MEMORANDUM

TO: Jean Fraser, Planner
FROM: David Senus, P.E.
DATE: July 6, 2015
RE: 1342 Congress Street Neighborhood Center, Final Level III Site Plan Application

Woodard & Curran has reviewed the response to comments and Final Level III Site Plan Application submittal for the for the proposed Neighborhood Center at 1342 Congress Street. The project involves the construction of a 19,300 SF building with associated site improvements that include a surface parking lot, stormwater management system, utilities, site lighting, and landscaping. The project will disturb approximately 85,000 SF and result in 12,500 SF of additional impervious area.

C-2B

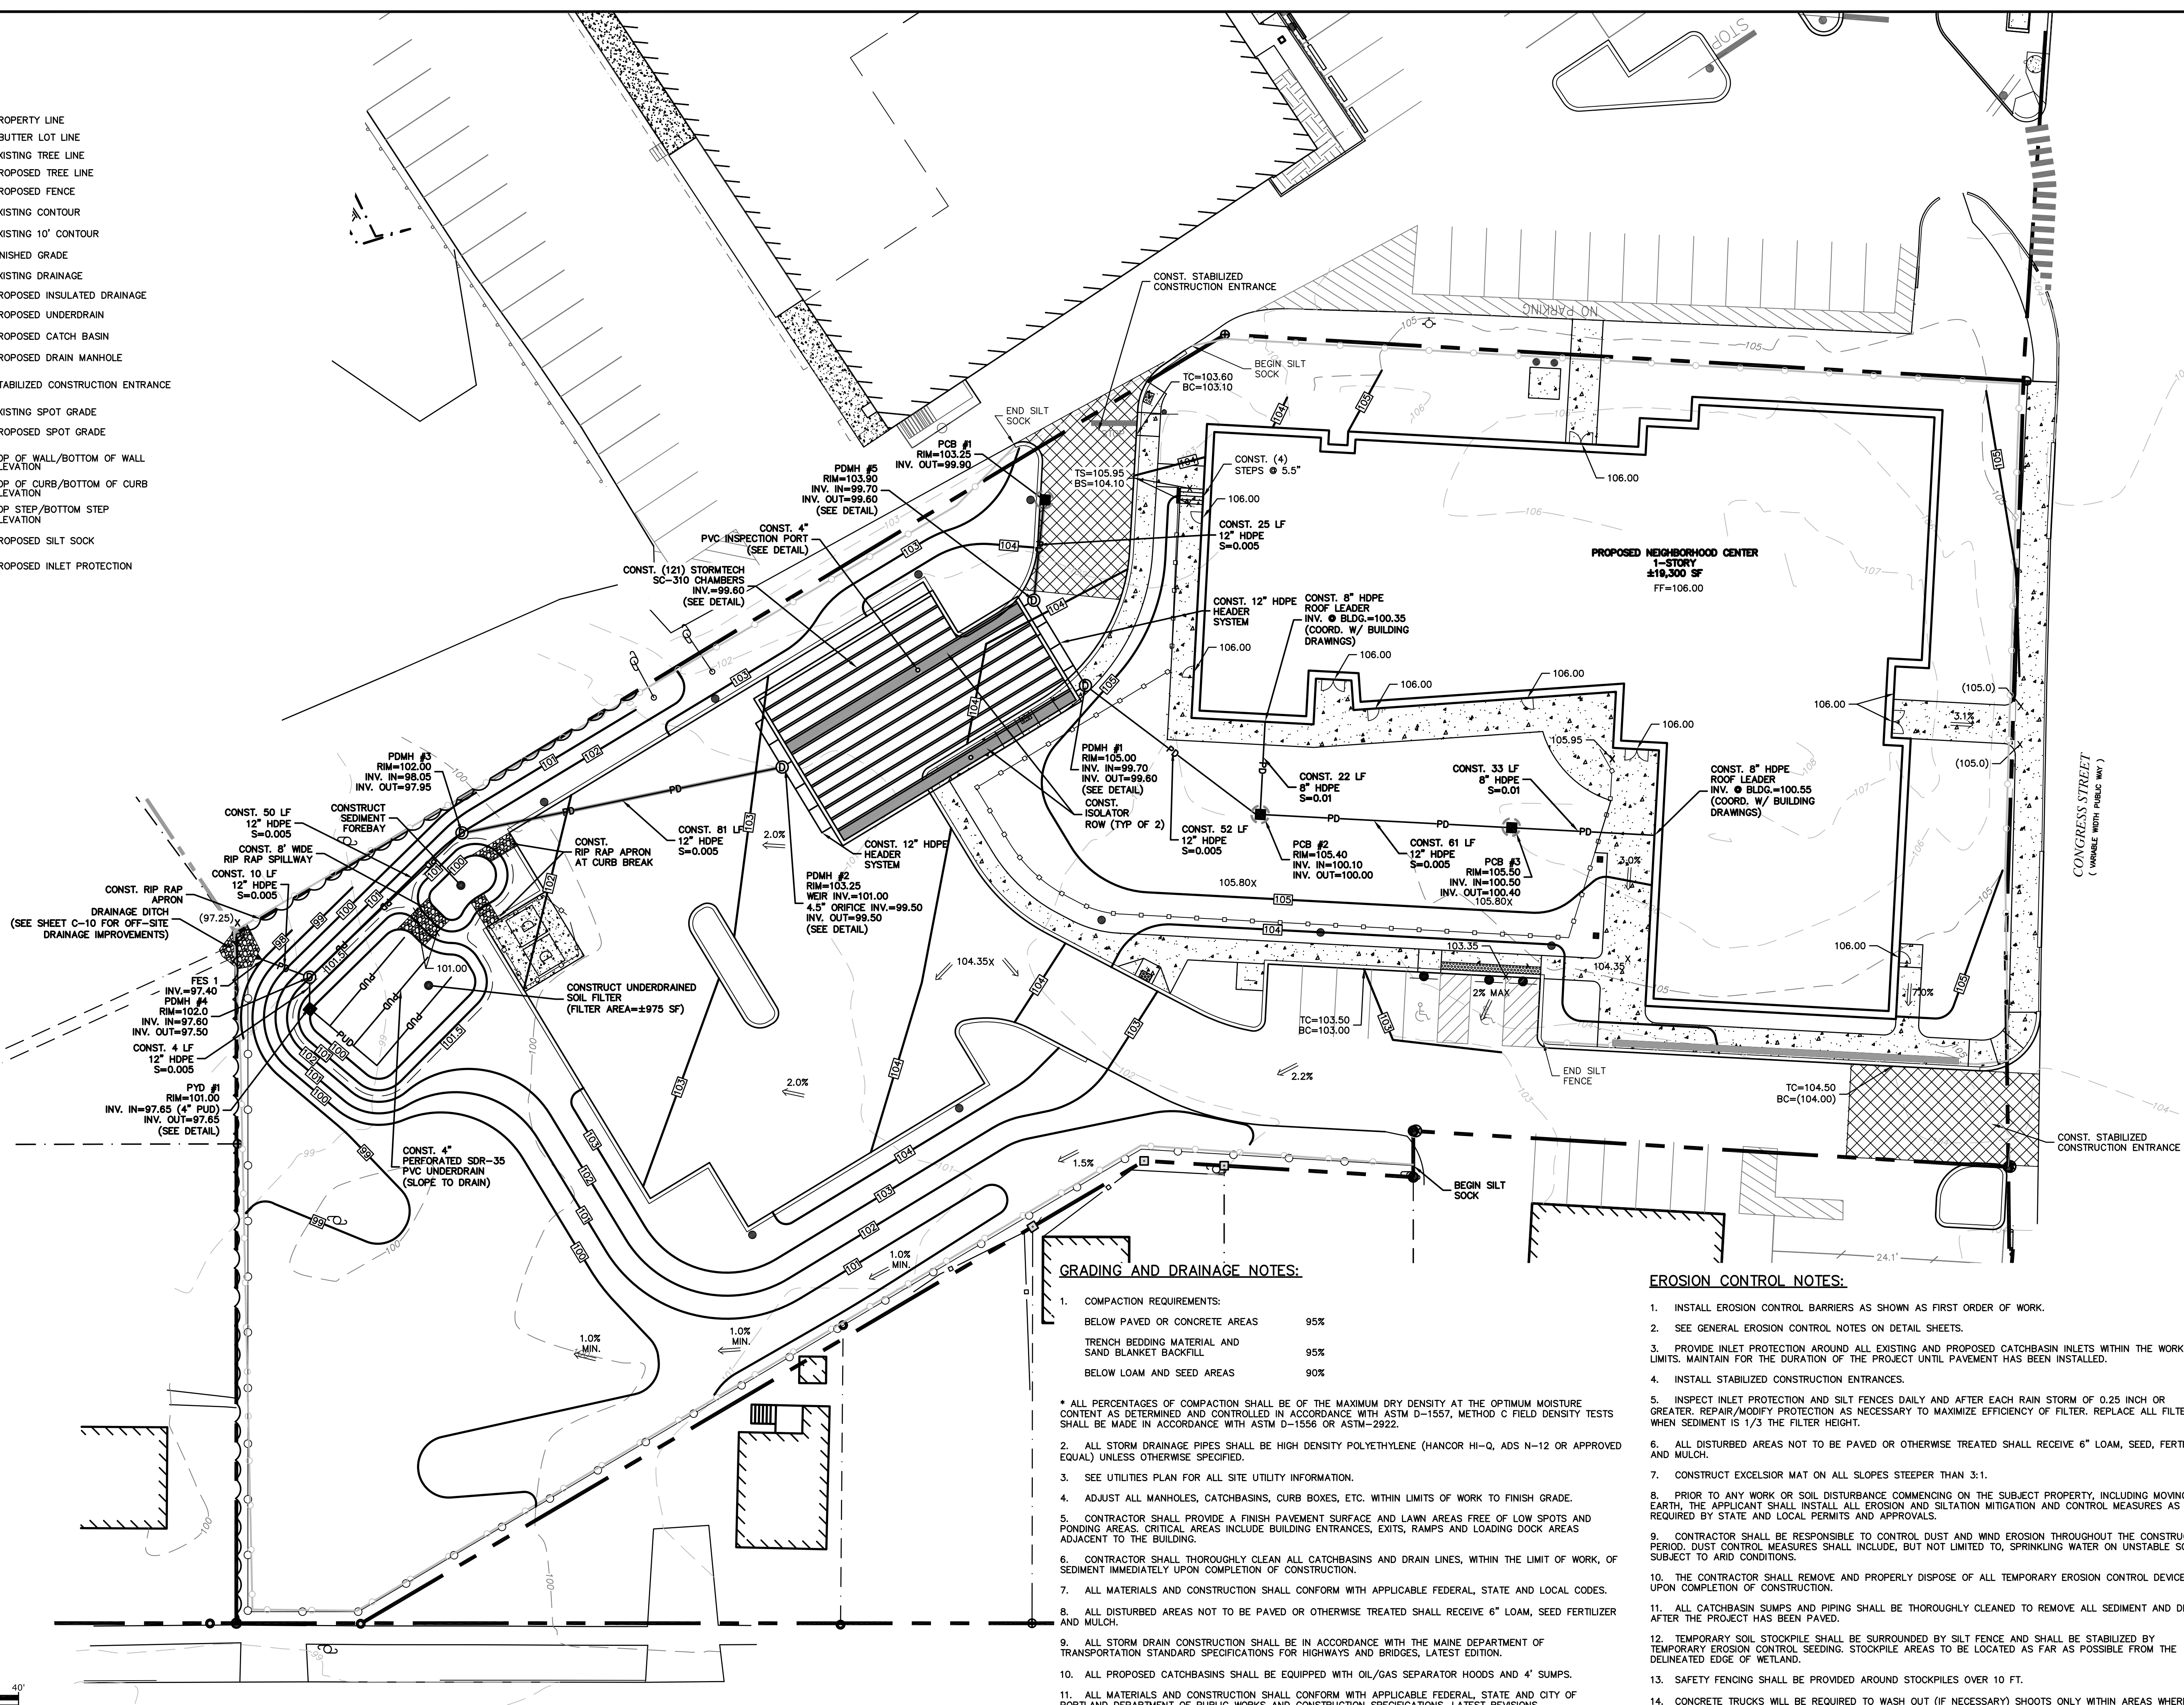
- 4) Sheet C-2b depicts snow storage along the east edge of the rear parking lot, adjacent to several residential properties. The grading plan (C-3) indicates that runoff from this area would potentially flow onto these properties. The Applicant should limit snow storage in this area and should revisit the proposed grading to ensure that runoff from the project property is not directed onto these abutting residential lots.

VERTICAL GRANITE CURB
NOT TO SCALE

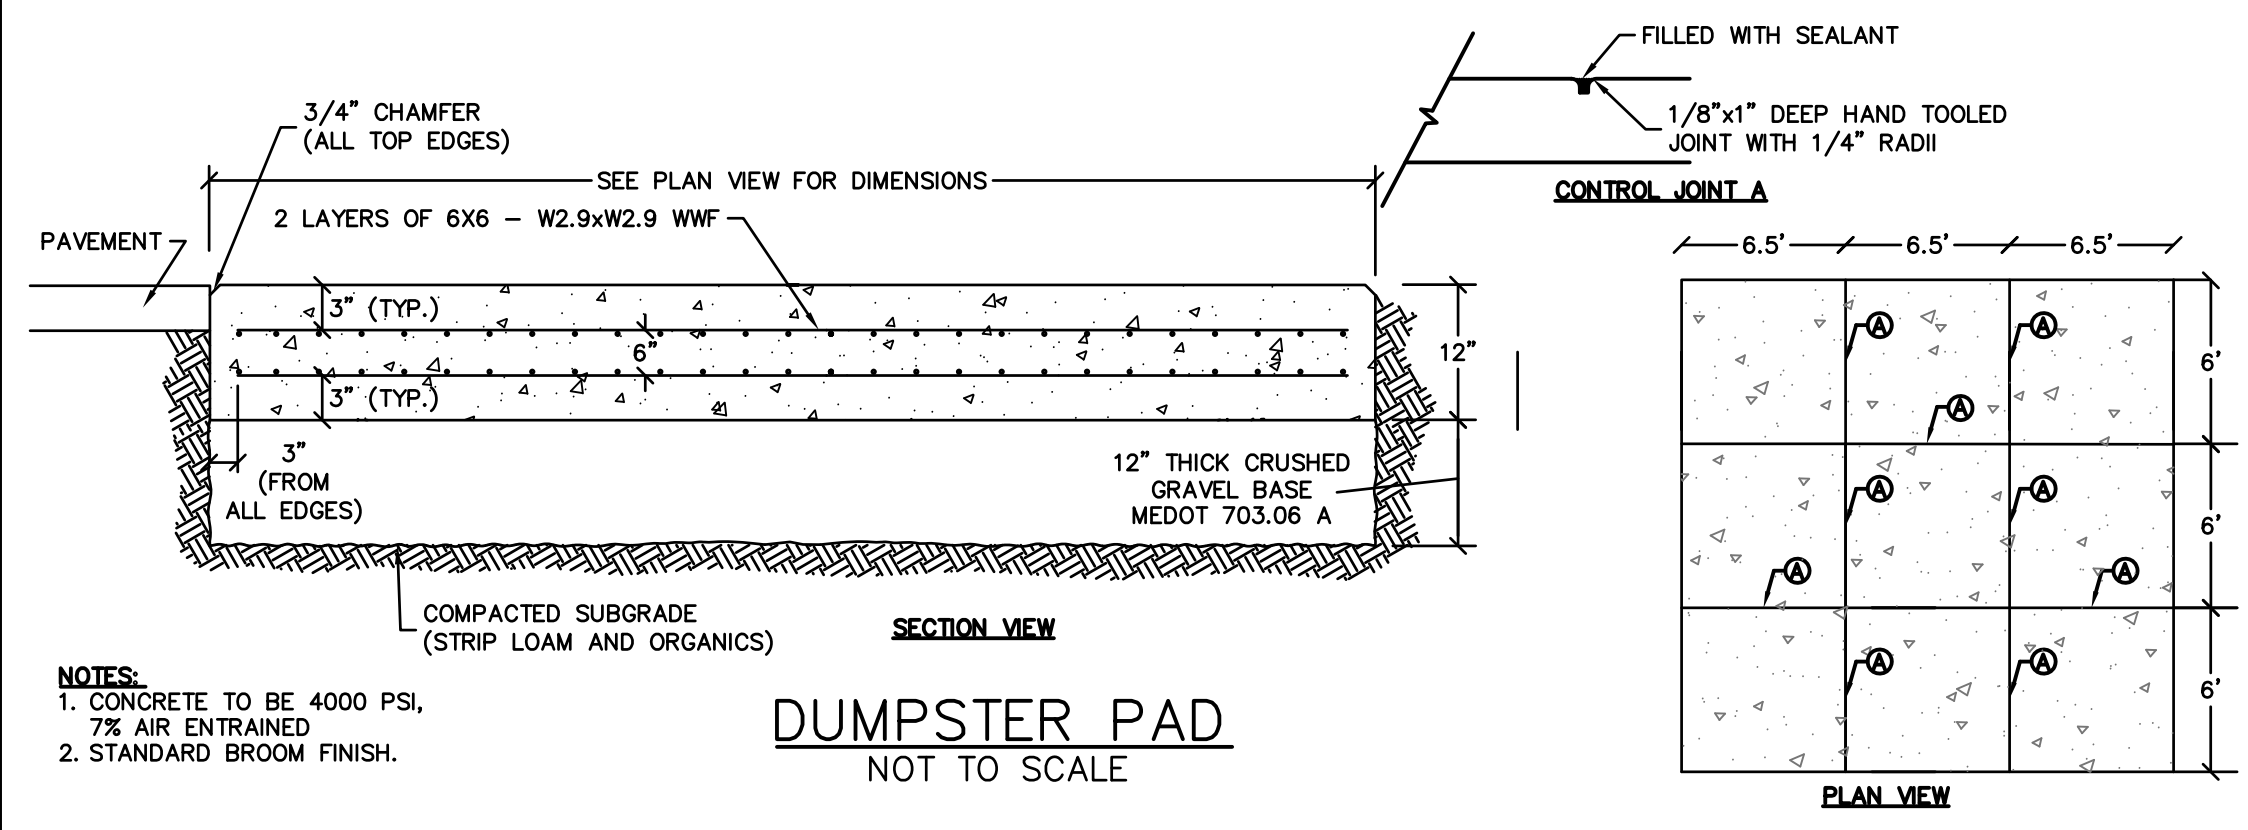
- 7) The proposed Vertical Granite Curb, Concrete Sidewalk, and Utility Trench details should be revised to comply with the City of Portland Technical Manual for work within the City Right-of-Way.

CROSS SECTION UNDERDRAINED SOIL FILTER
DETAIL
NOT TO SCALE

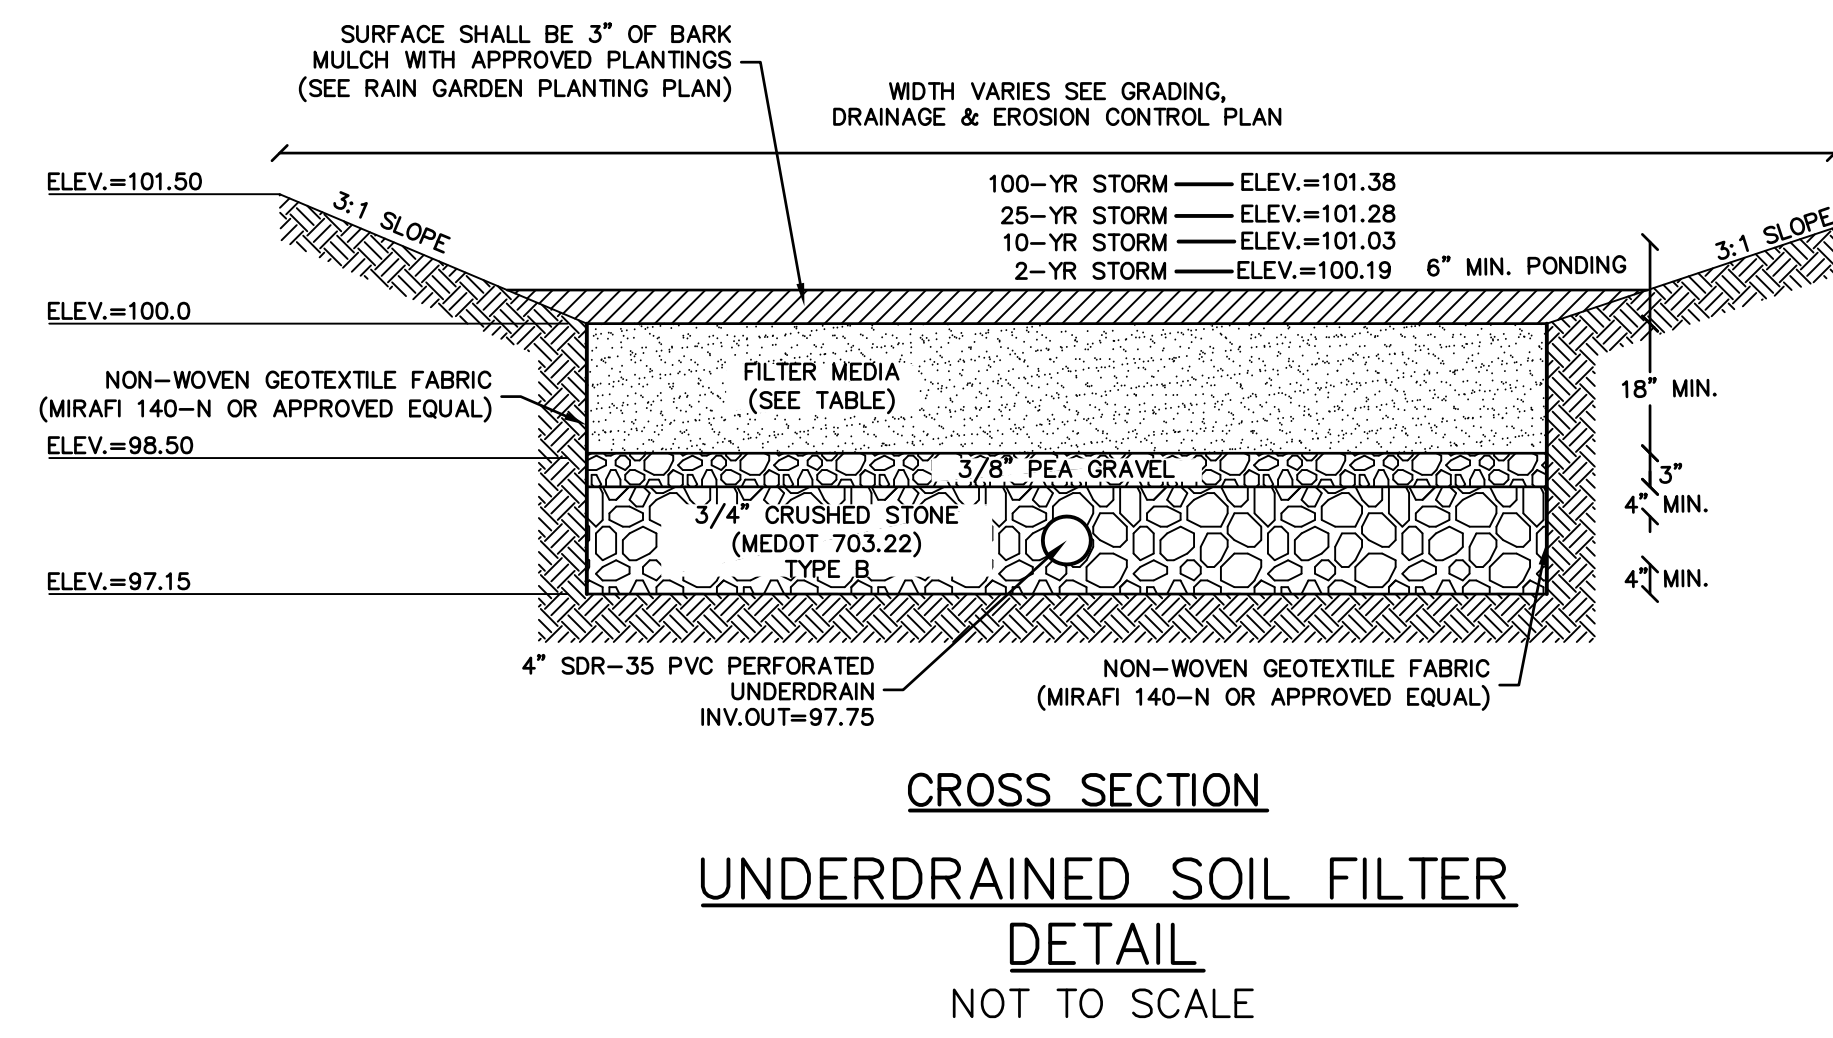
- 6) The proposed Underdrained Soil Filter Bed detail refers to a Rain Garden Planting Plan for proposed plantings; however, it does not appear that this plan has been provided at this time.
